Please ask for: Nicola Moore
Email: nicola.moore@arun.gov.uk
Telephone: Ext 37944
Our Ref: WA/106/20/DOC
Your Ref:
Date: 6th January 2021

Approval of matters reserved by condition

Development: Approval of details reserved by condition imposed under ref WA/22/15/OUT relating to Condition Nos 6 - materials & finishes, 10 - hard & soft landscaping, 11(a) - protection of retained trees, 12 - surface water drainage, 14 - maintenance & managements of SuDs, 15 - foul drainage, 19 - Construction Management Plan, 20(d) - forecourt layout, drainage, position & intensity of lighting fitments, 21 - noise control, 25 - Travel Plan and 26 - non-motorised users audit.

Location: Gtr Ltd Arundel Road Fontwell Arundel BN18 0SB

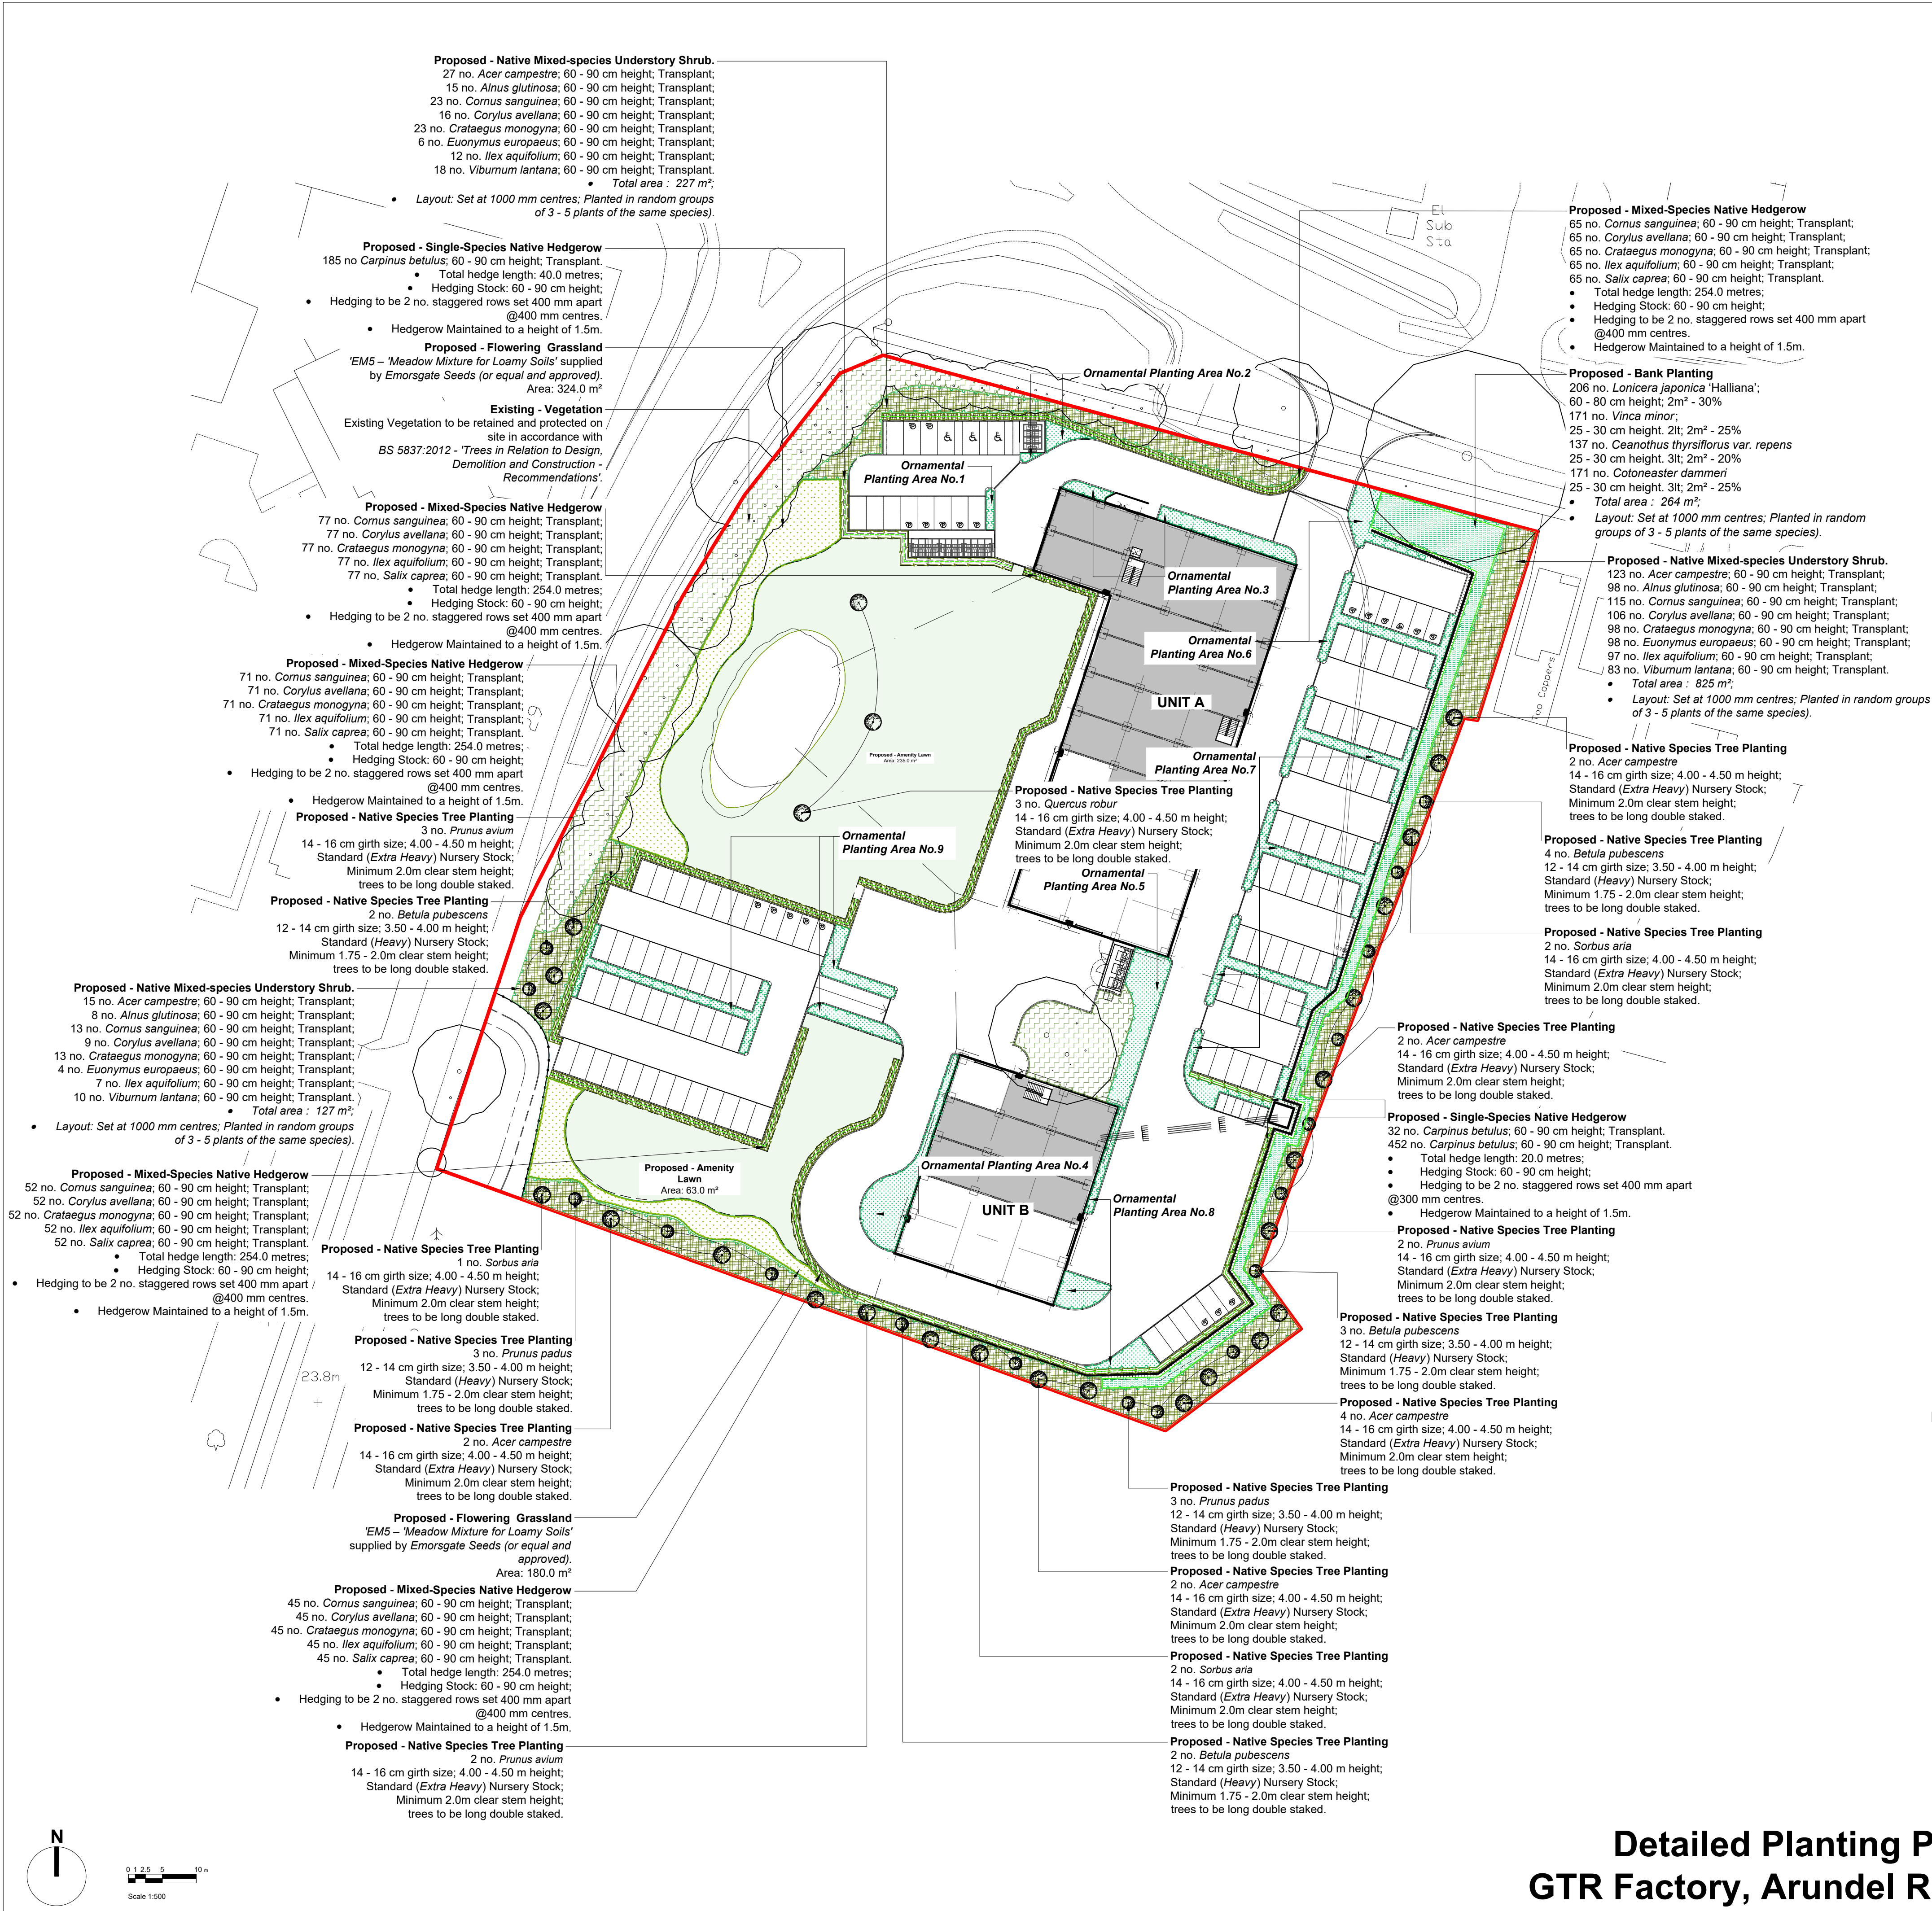
Condition No 10 - Dwg No LLD1773-LAN-DWG-202 Rev 03 is listed on the schedule of drawings, however, rev 02 has been submitted. Please submit the correct drawing.
